389 Congress St.Rm 315
Portland, ME 04101
Phone: (207)874-8700
Fax: (207)874-8716

Re: 340 Commercial St.

I have reviewed the submissions for Permit #031067 and have the following questions/comments:

E5 STAIR E SECTION
1/4" = 1'-0" AE402

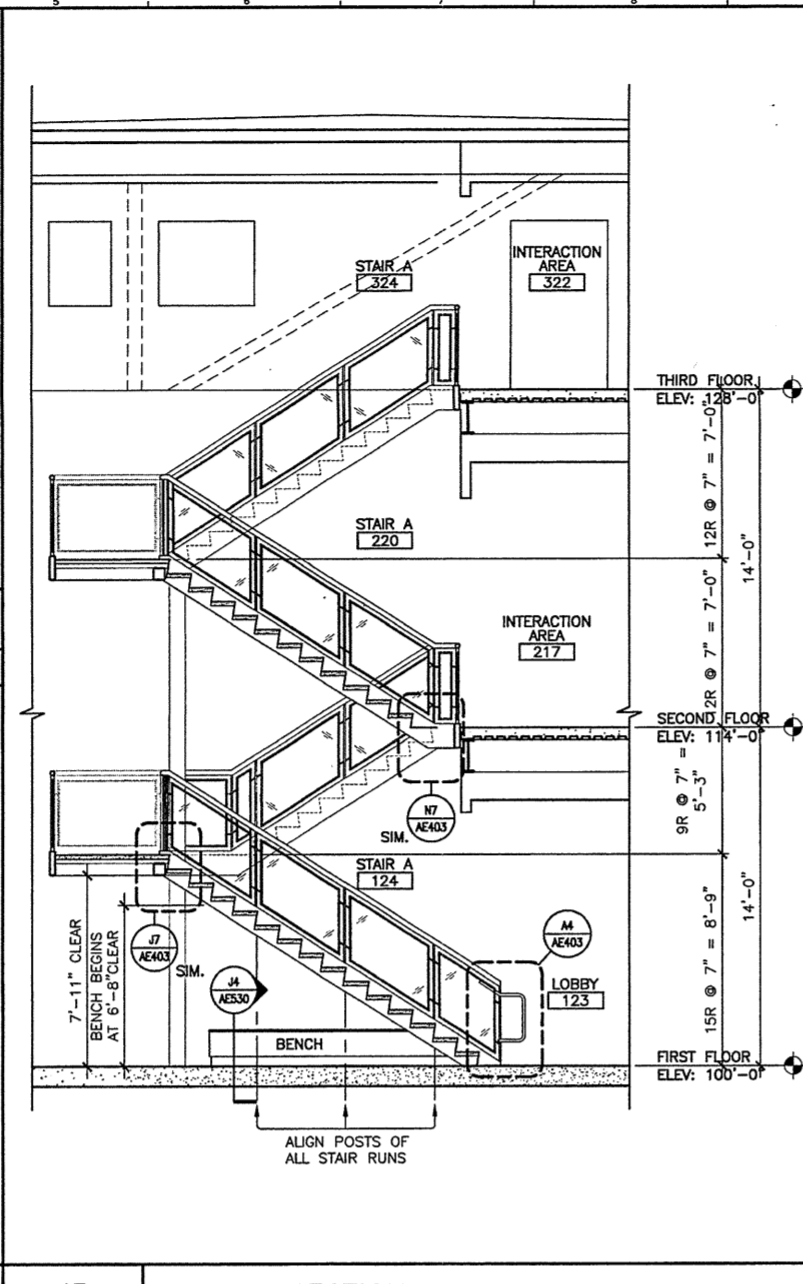
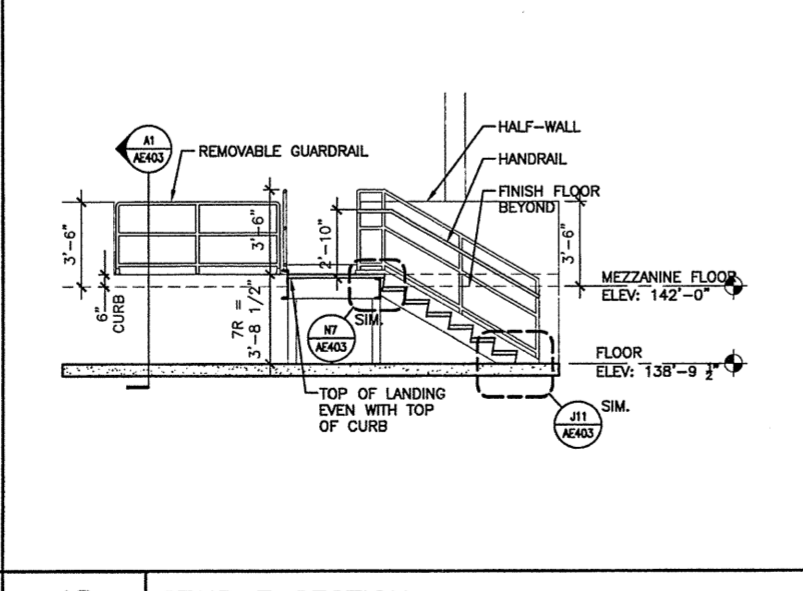
- 1) I need a dimensional detail for the alternating tread stair that shows treads risers width, headroom and guards, please look at Section 1014.6.6 and 1022.0.
- 2) How are you classifying the use group of the 4th floor (I assume you are using the openings in guard option in Secion 1021.3)?
- 3) The guards are removable in a portion of this area, I'd like to talk about this from an operations standpoint.
- 4) The handrail in fig. E5 on page AE402 is 32", (must be 34")
- 5) Need specs on the smoke removal system specs for the atrium.
